CITY OF ALBUQUERQUE

January 19, 2018

**RE: Coors Pavilion Lot 4 (Panera Bread)
9154 Coors Blvd
Request for Certificate of Occupancy
Hydrology Final Inspection- Not Approved
Engineer's Stamp Date: 5/31/17 (G11D069A)
Certification Dated: 1/16/18**

CITY OF ALBUQUERQUE  
PUBLIC WORKS DEPARTMENT  
ENGINEERING DEVELOPMENT GROUP  
**COORS PAVILION SUBDIVISION**  
**LOT 4 & PORTION LOT 5**  
**GRADING & DRAINAGE PLAN**

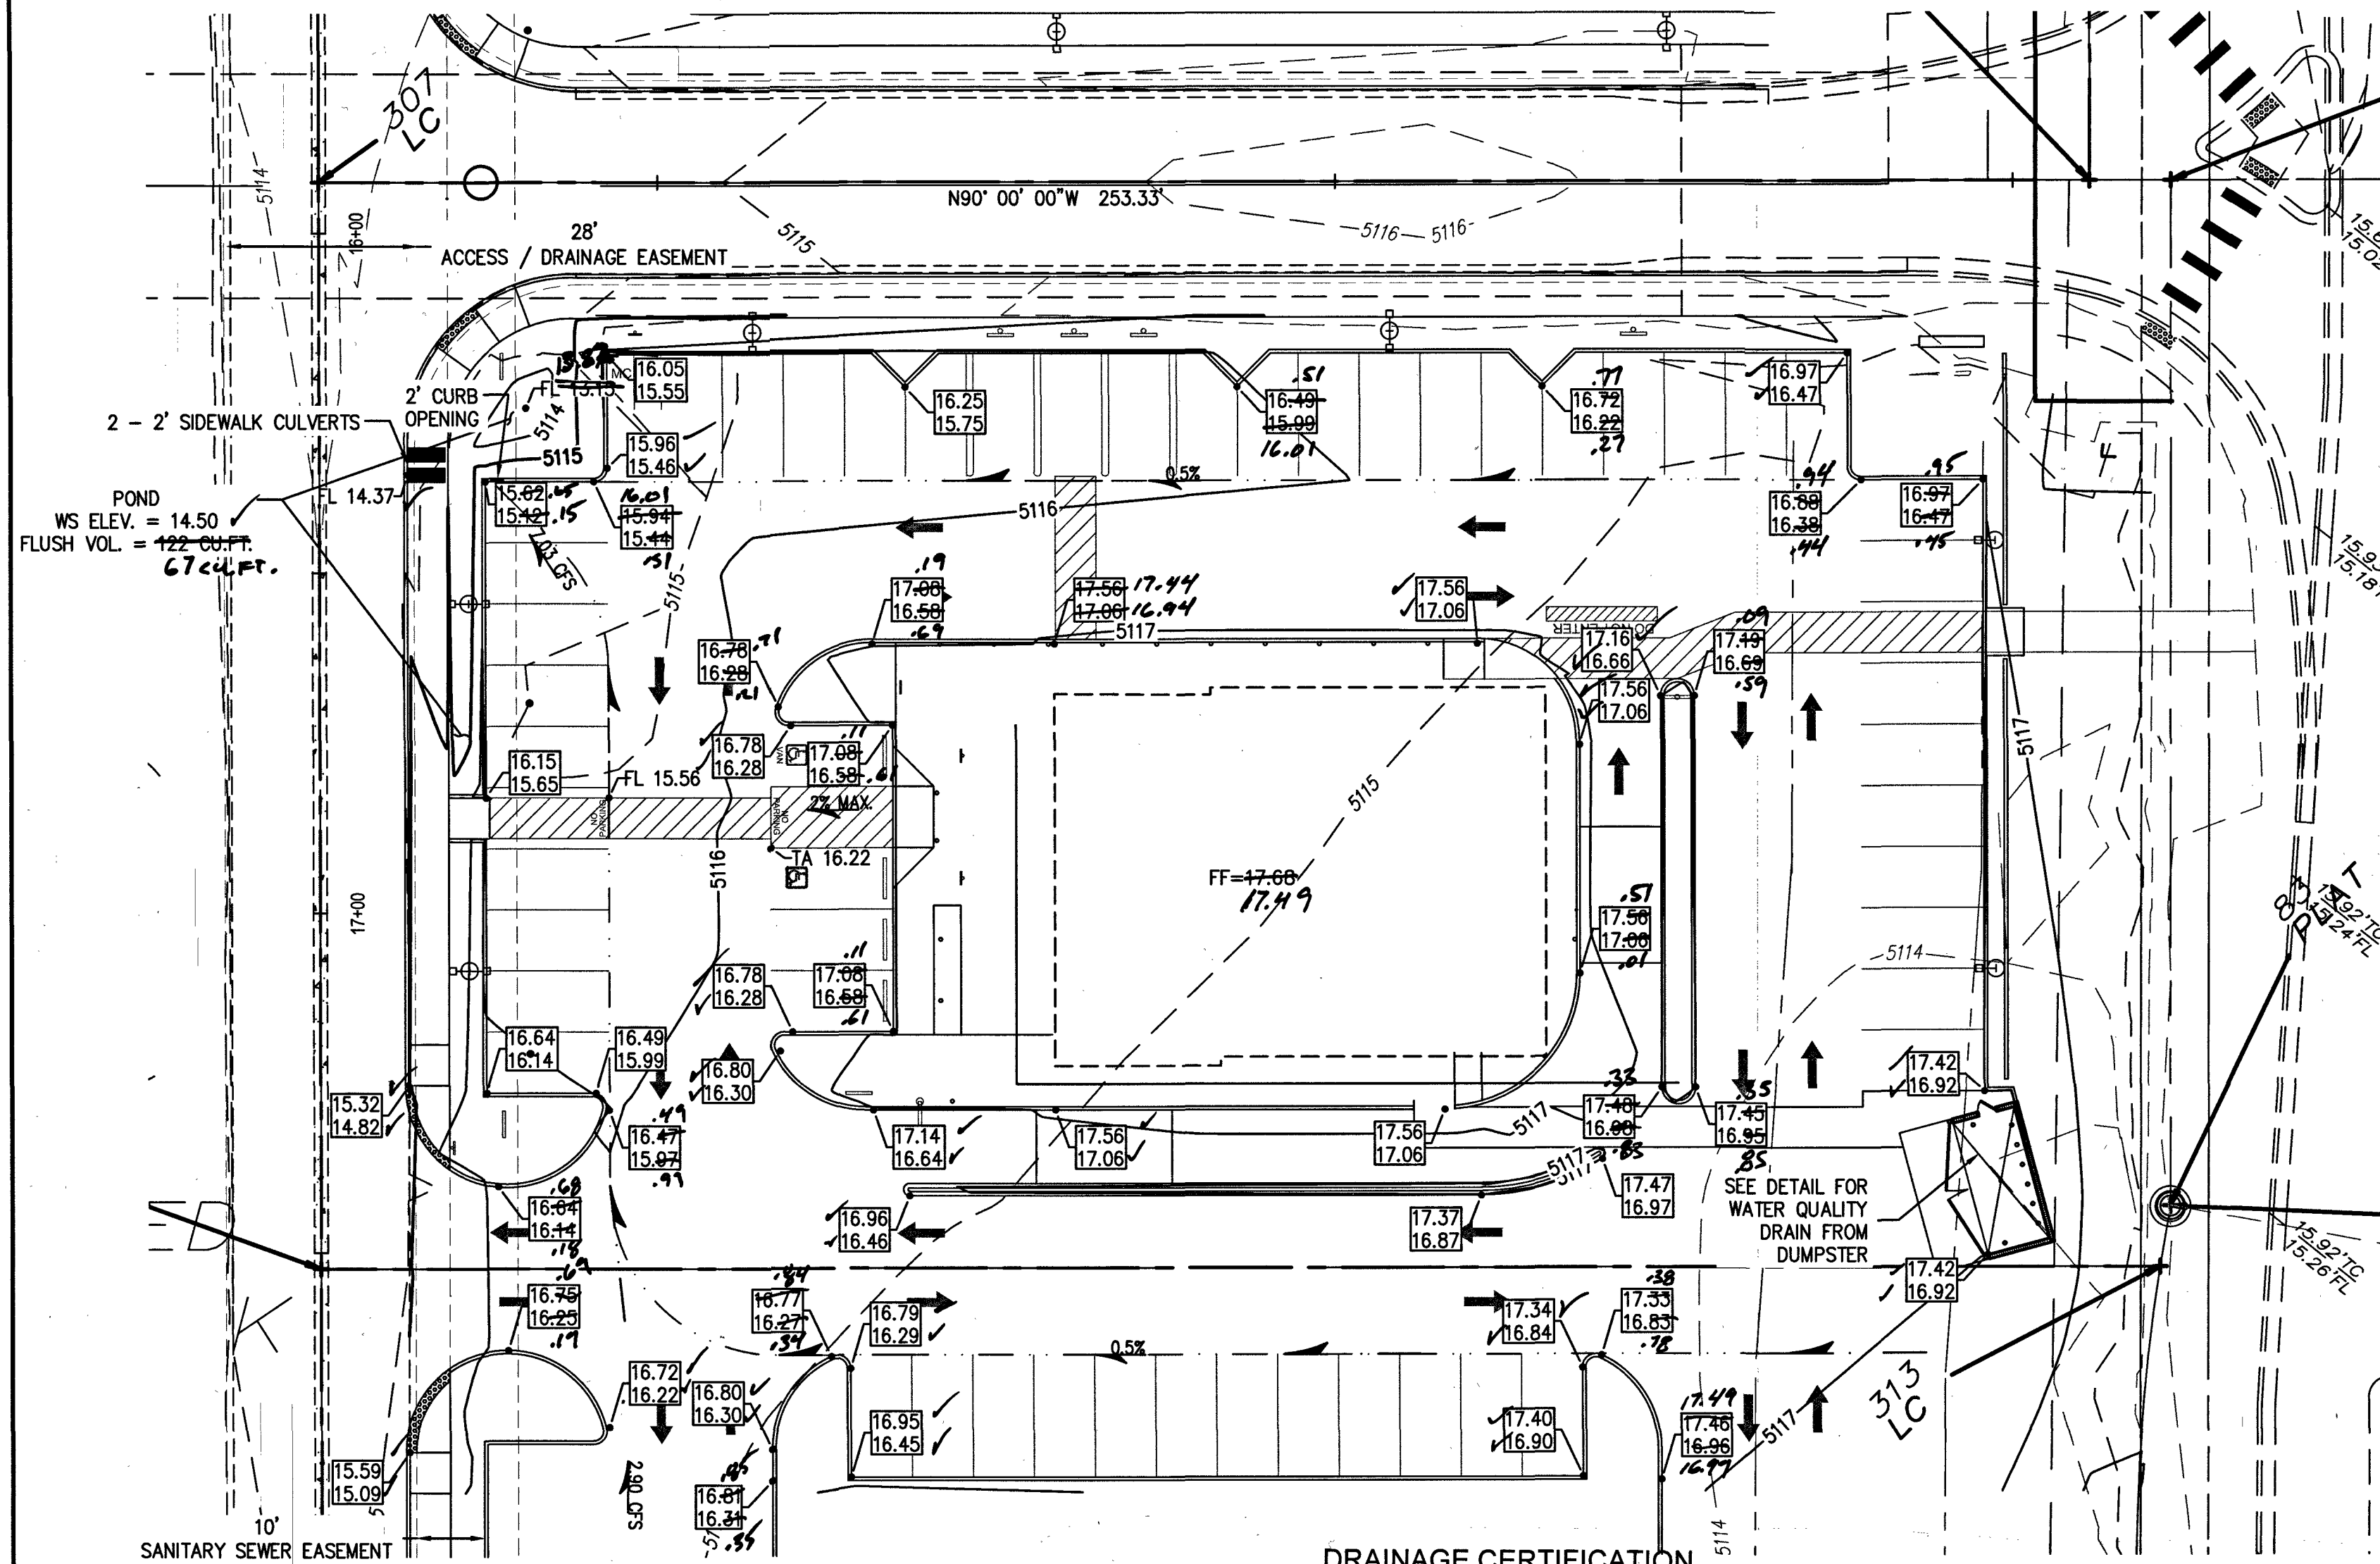
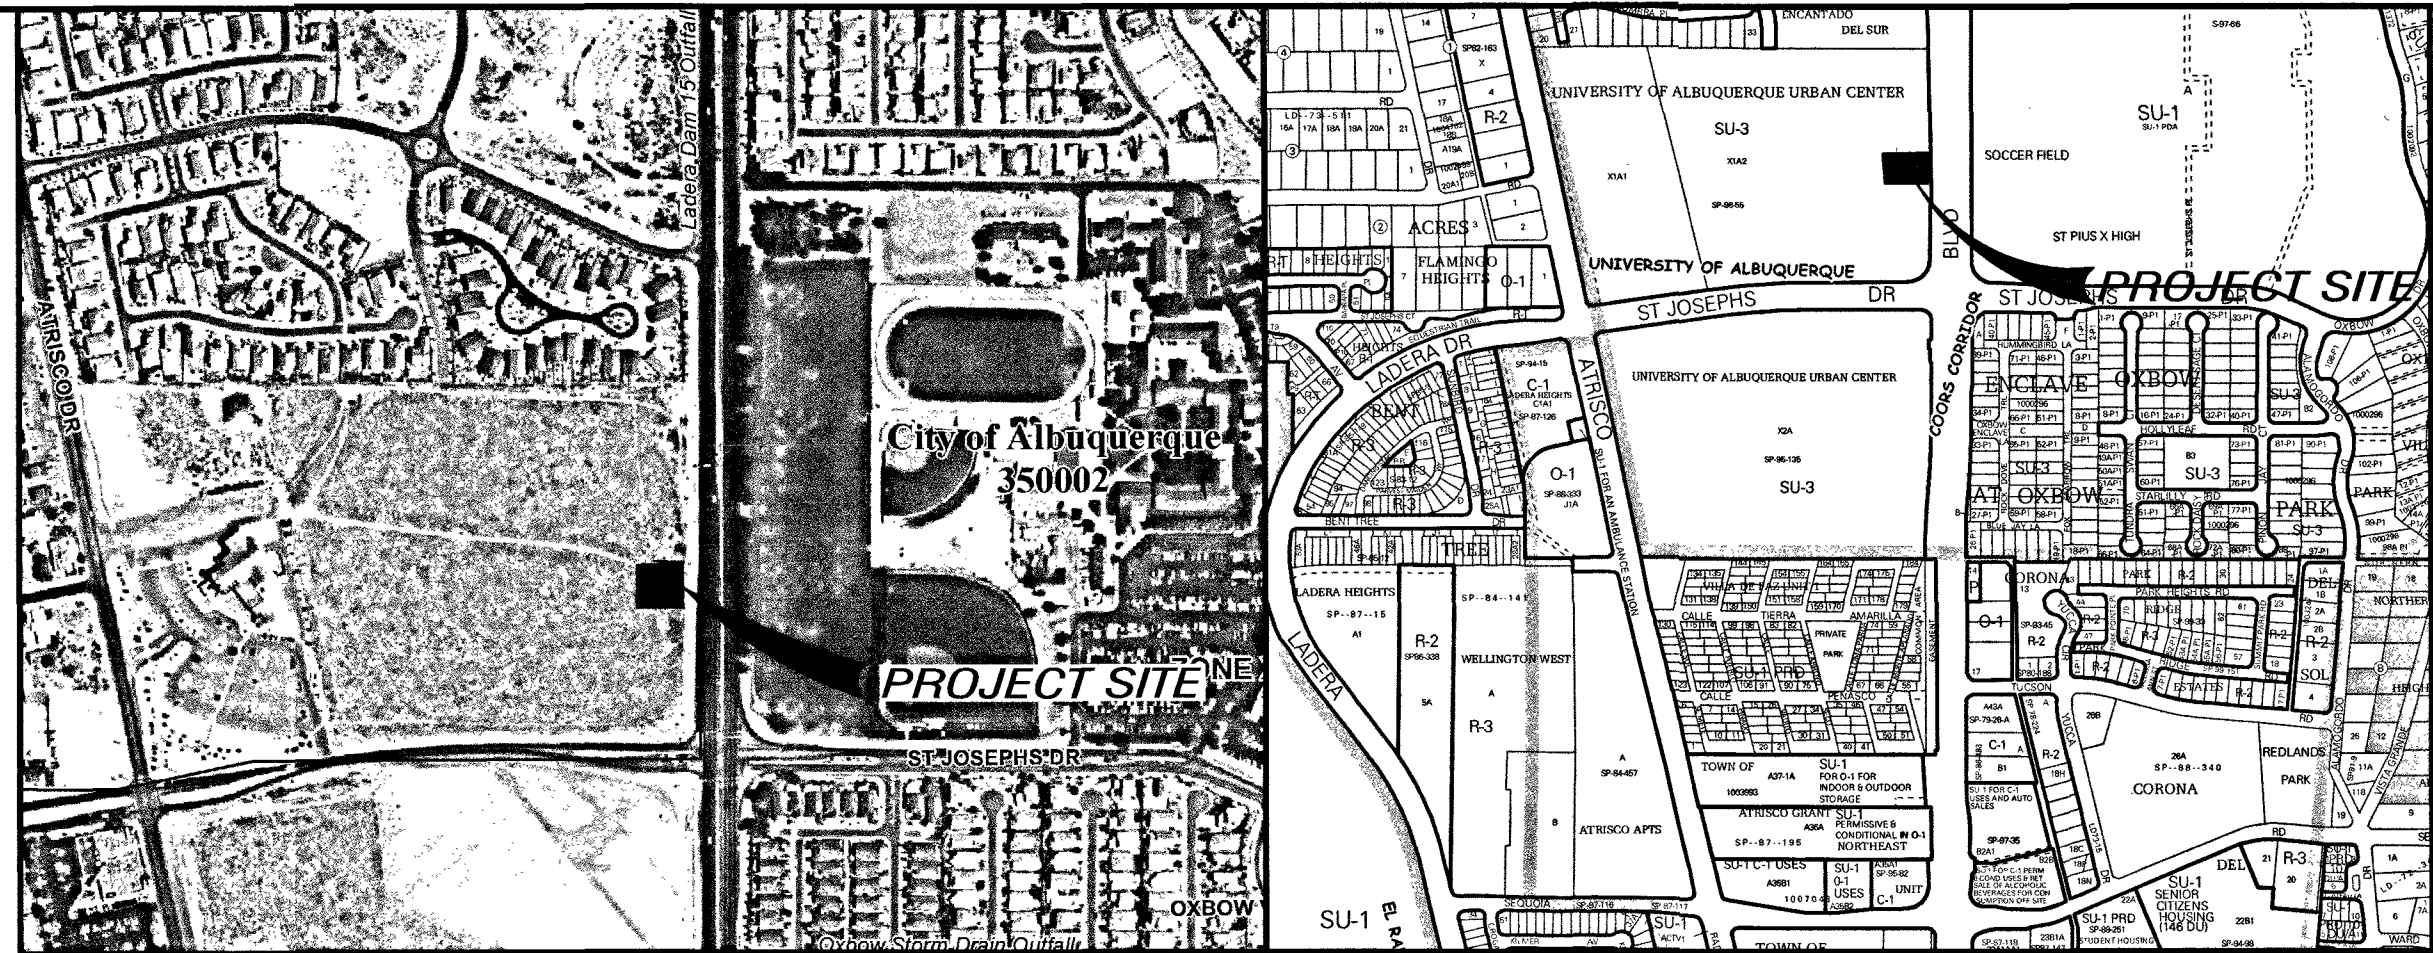
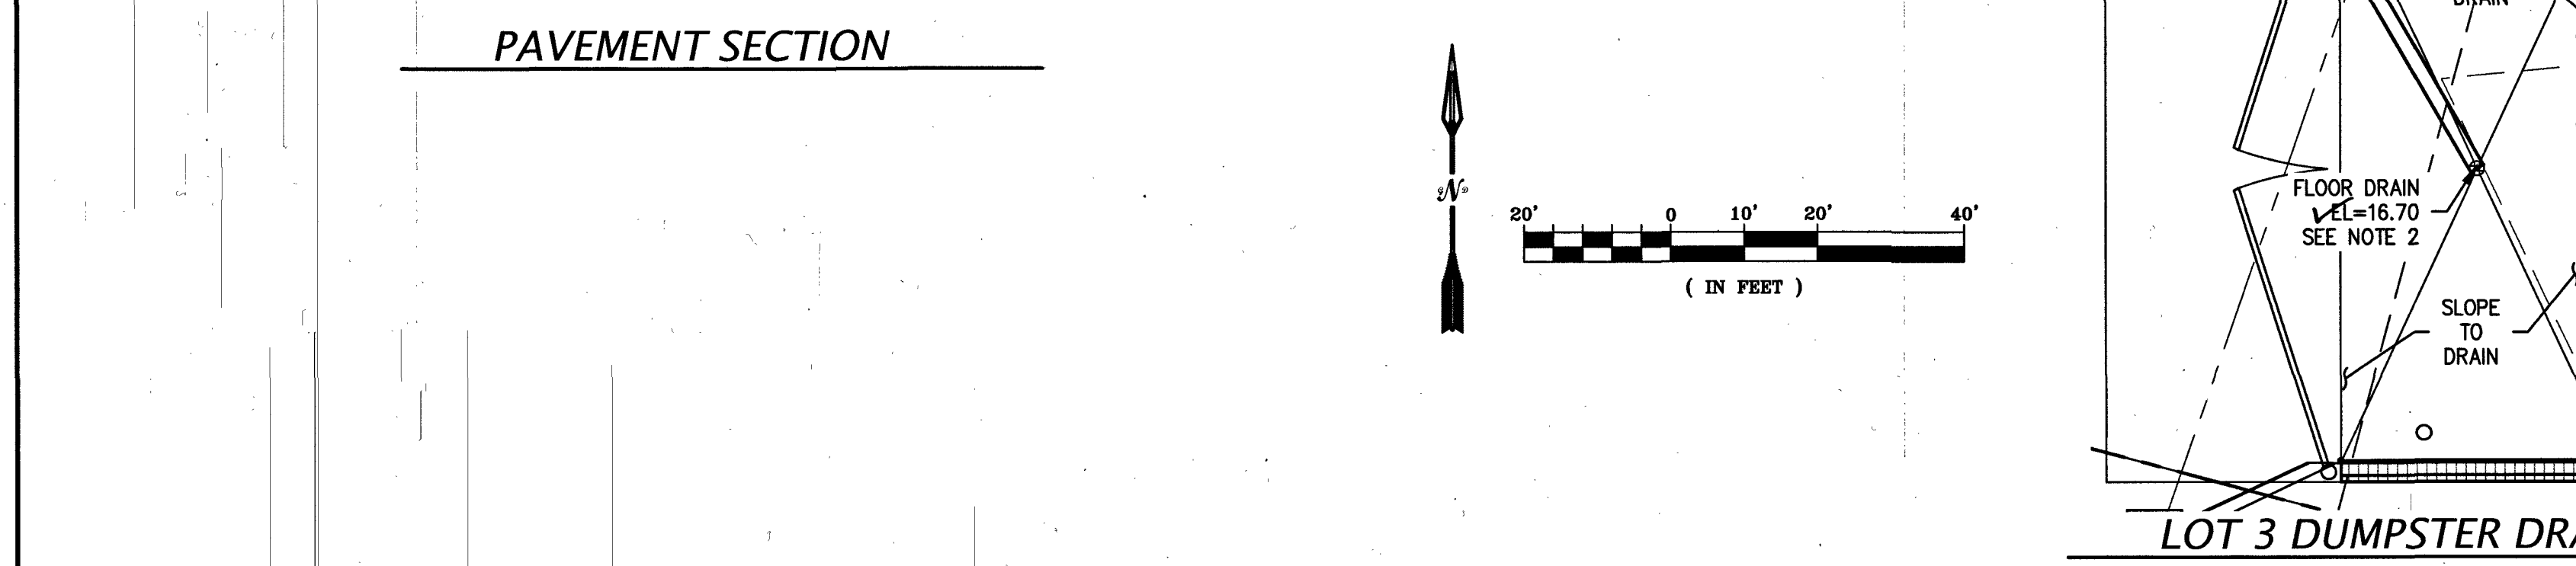
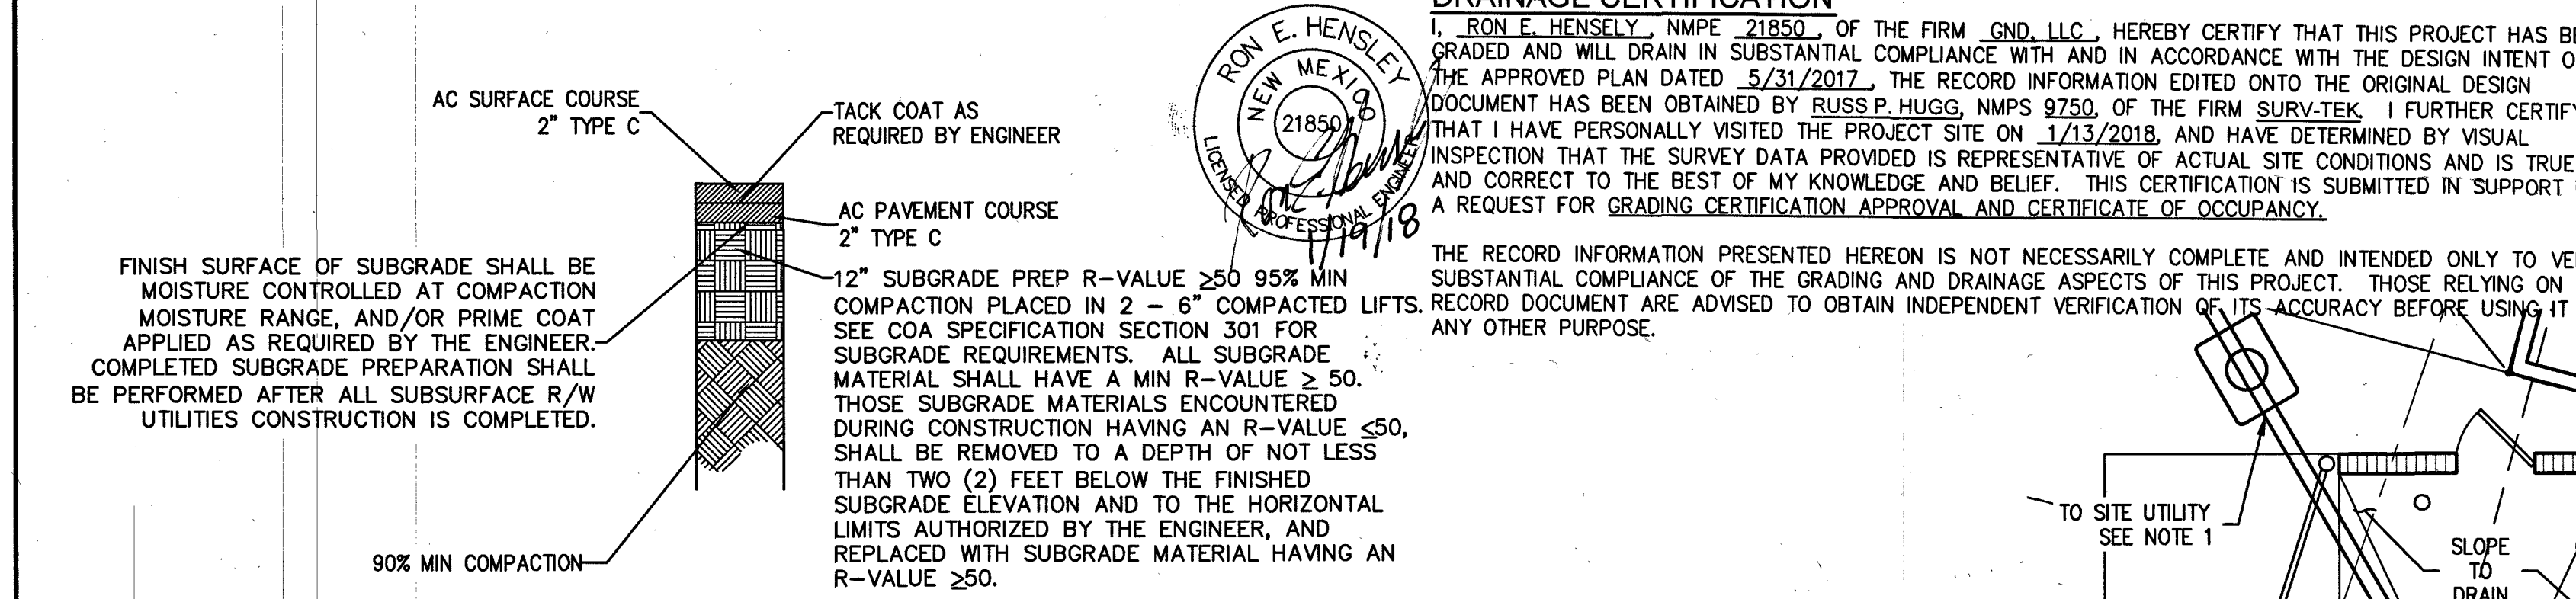
1. The ¾" steel rods welded to the street side of the sidewalk culvert need to be ground flush and smooth with the face of curb. Once complete, provide photo of the corrected culverts.
2. The small first flush pond in the NW corner is smaller than shown on the approved Grading Plan. The new pond size needs to be shown on the drainage certification, along with its new volume and elevations.
3. Please include the utility sheet, showing the location of the grease trap and drainline from the dumpster with your resubmittal.
